CITY OF ALBUQUERQUE

**Re: La Luz Del Oeste
Engineer's Stamp Date 11-6-15 (F11E02A)**

Based upon the information provided in your submittal received 11-6-15 the above referenced plan is not approved to be included in the SWPPP or for Grading Permit/ESC Permit or Work Order until the following comments are addressed:

## DETAILS

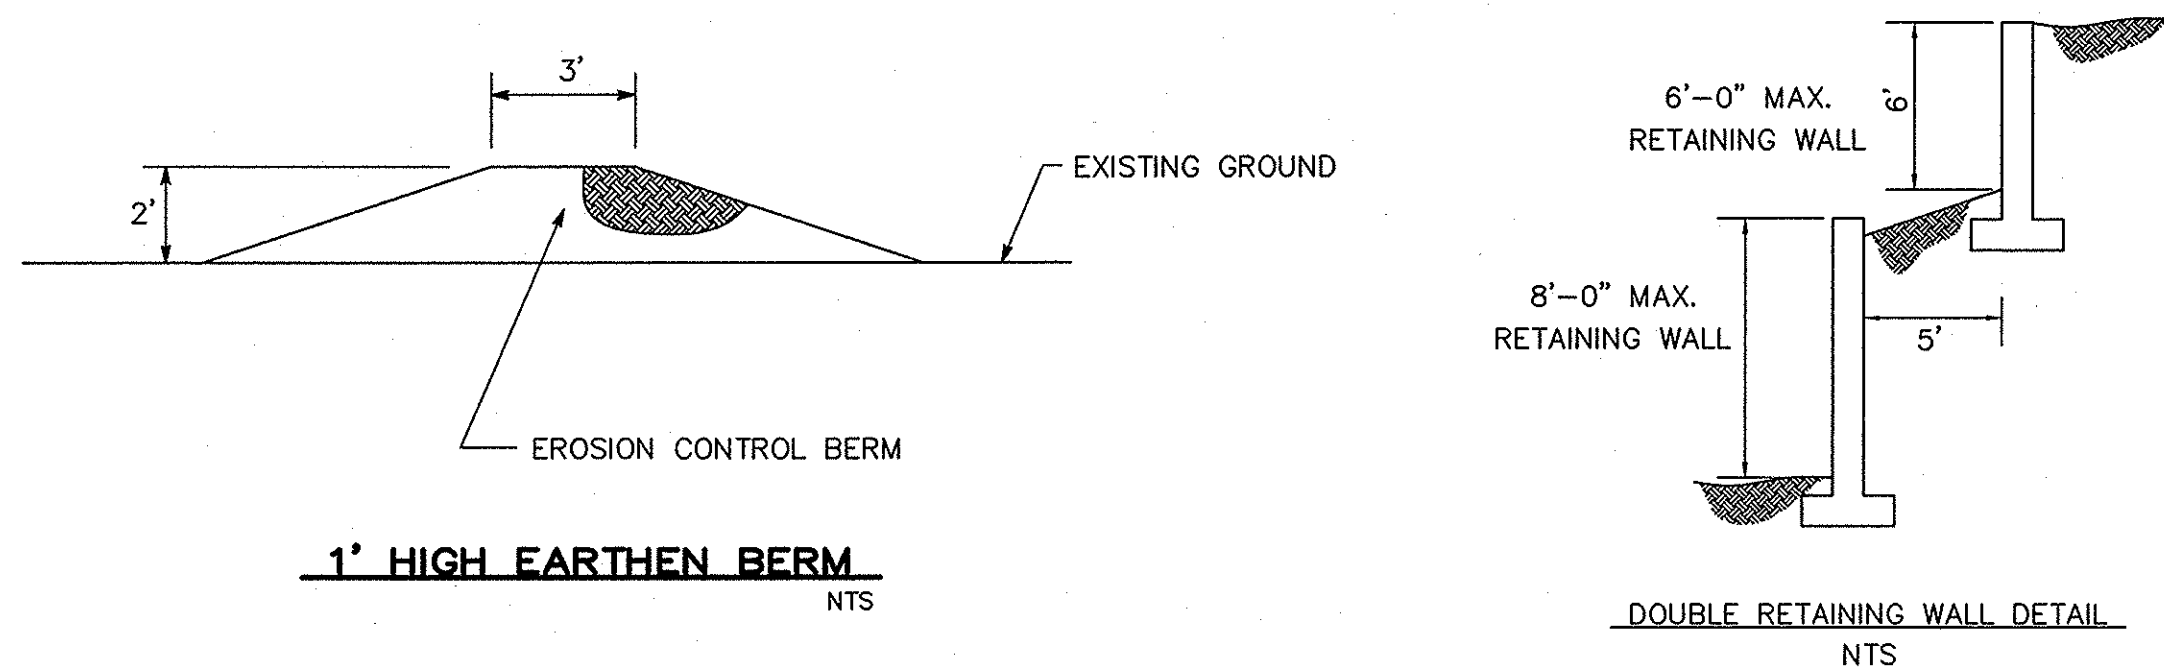
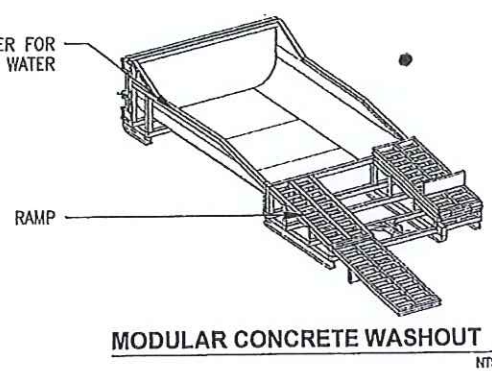
1. Propose super-elevating the road or a series of wattles across the road (to slow velocity) that connects to the existing development to the West.
2. The concrete wash-out location should be moved from behind the pond.
3. Seems that silt fence should not be required along the bottom third of the development where the houses area already built.
4. If the street connection in the northwest corner drains north, a BMP will be required to prevent sediment from leaving the site. The drainage area is small so a large wattle or silt fence would probably work.
